Your Ref: OWPC17381
Our Ref: AL/8/18/PL
Please ask for:
Mr S Davis

Erection of 2 No. 2 bedroom dwellings with associated parking & landscaping.
Land between 8 & 10 Barnett Close Eastergate

Thank you for your internet comments made on 15th February 2018 which has been recorded as **'an objection'** with the comments as follows:

location plan &
proposed site plan

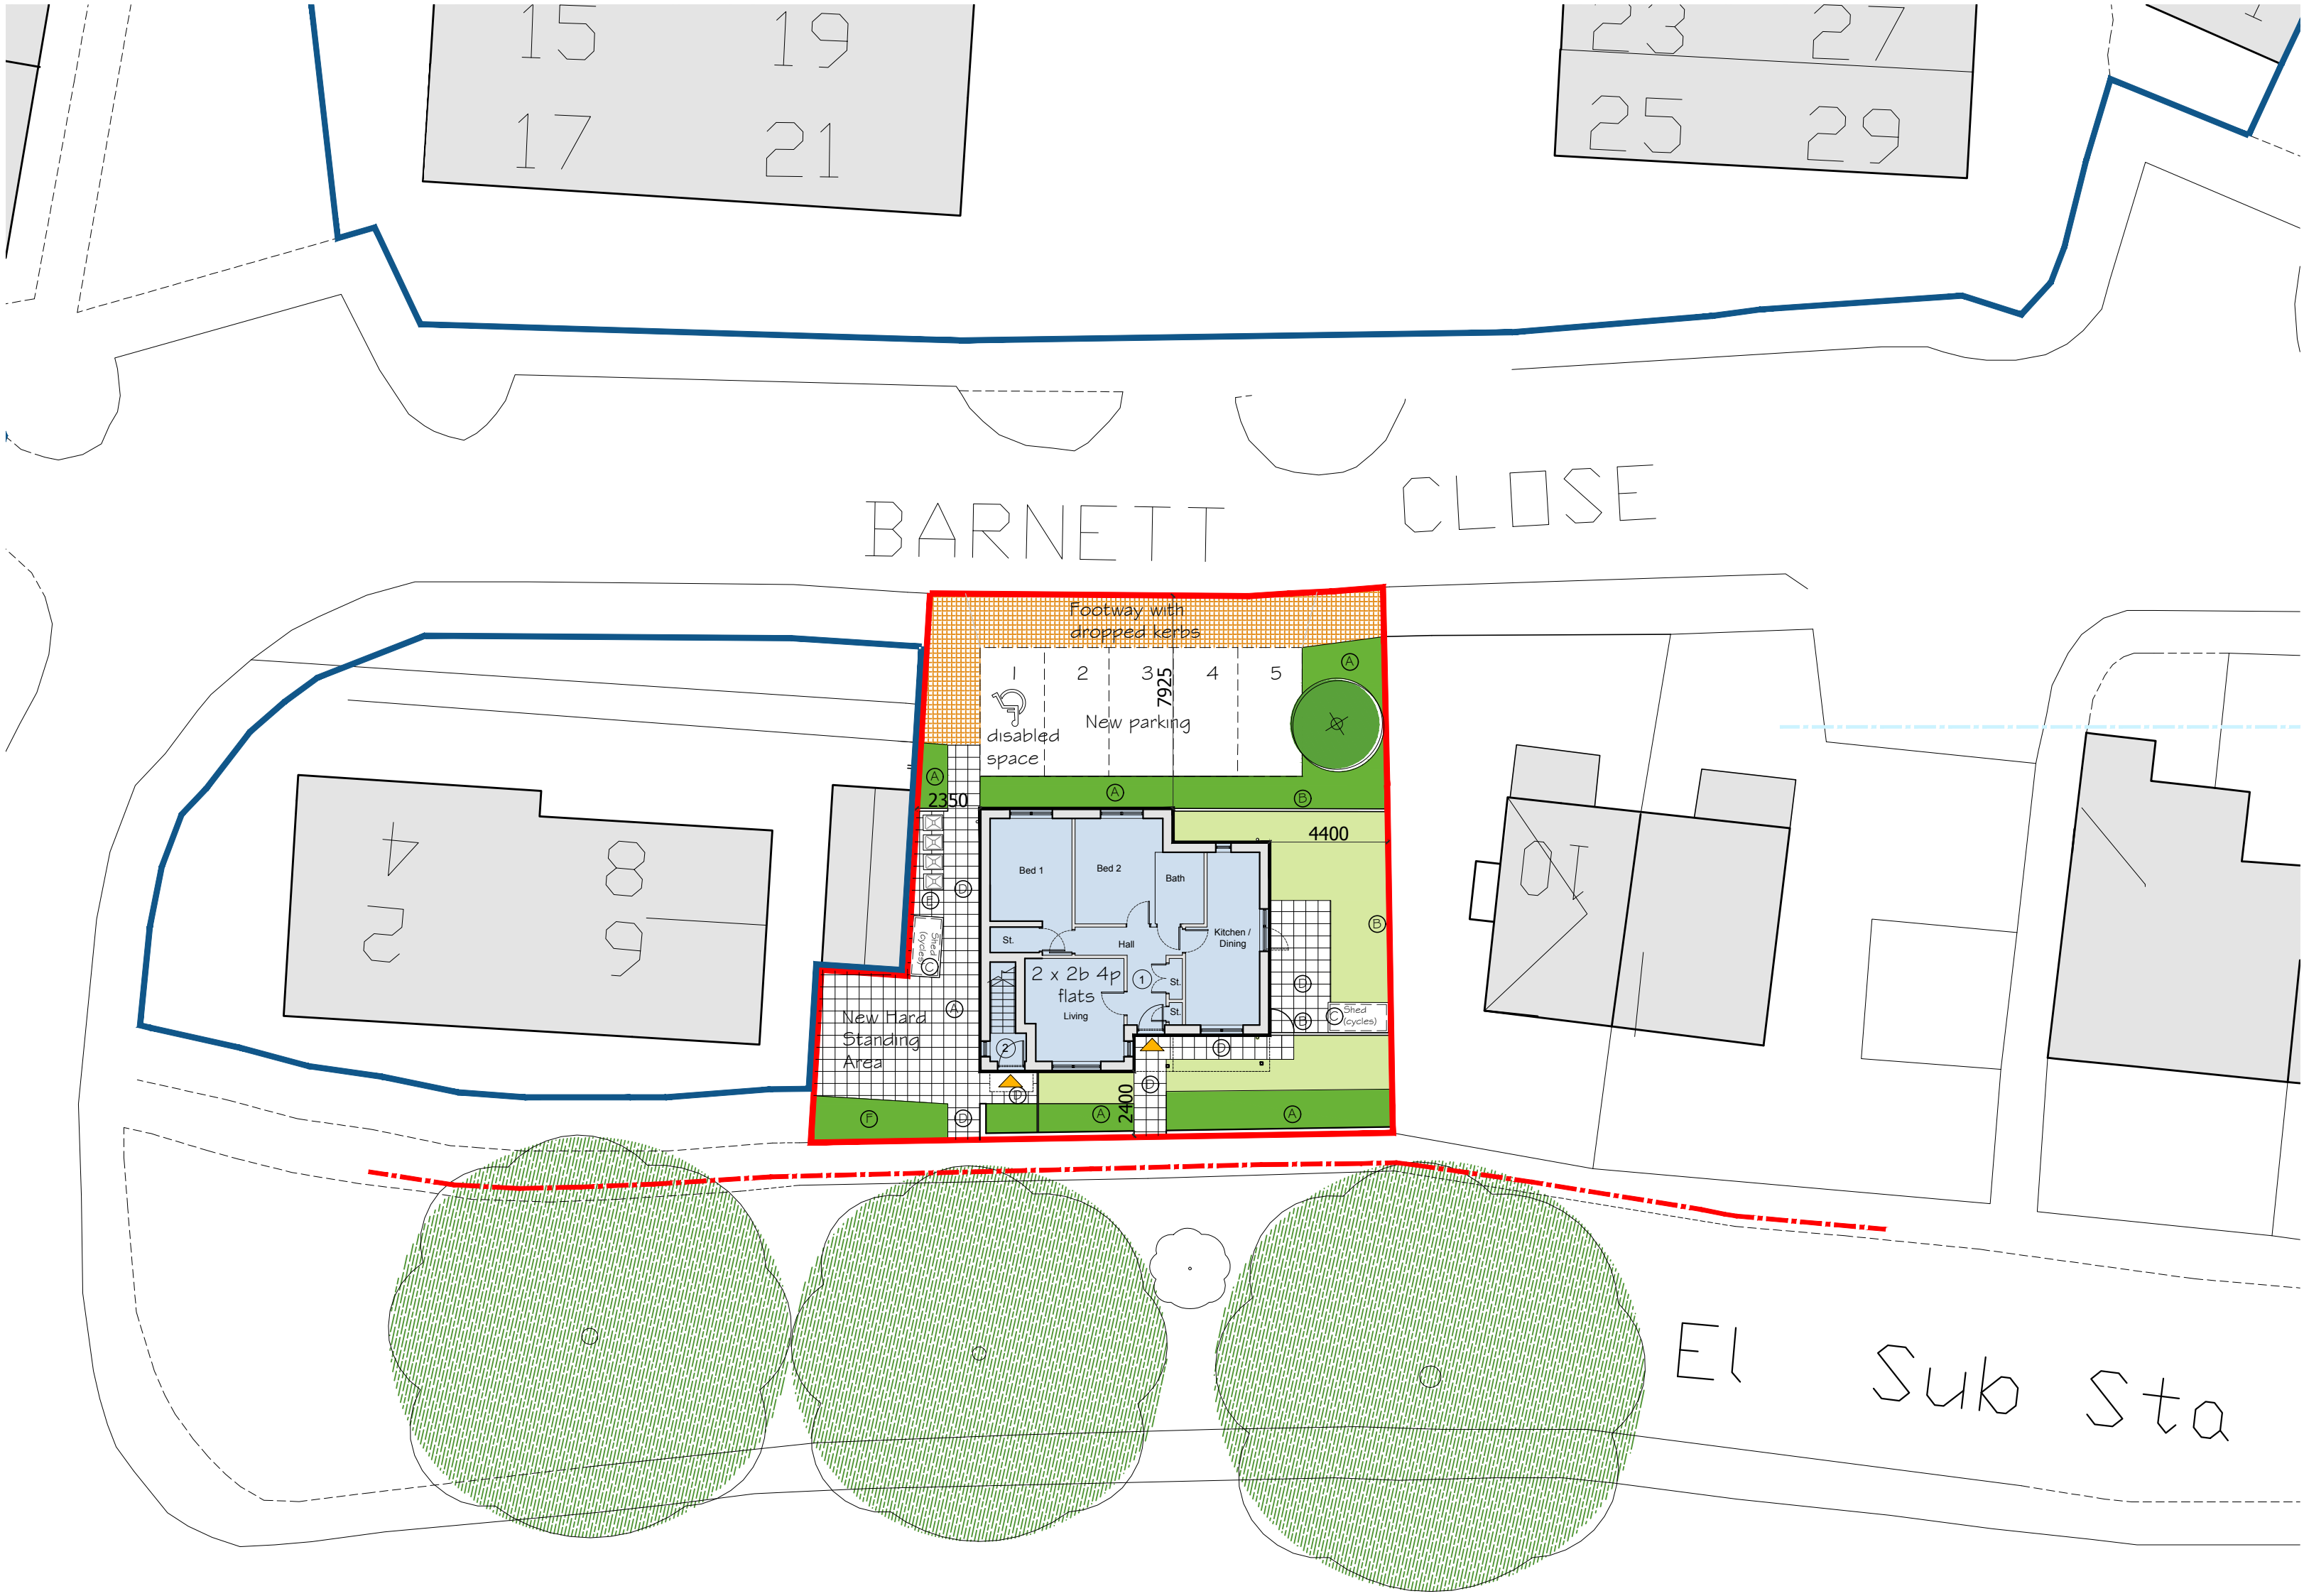
The Parish Council objects to this application. Please refer to policies H1 and H3, and 3.1 of the APC NDP. Currently the space is used for informal parking which will be lost. No additional parking has been provided which will impact on existing residents
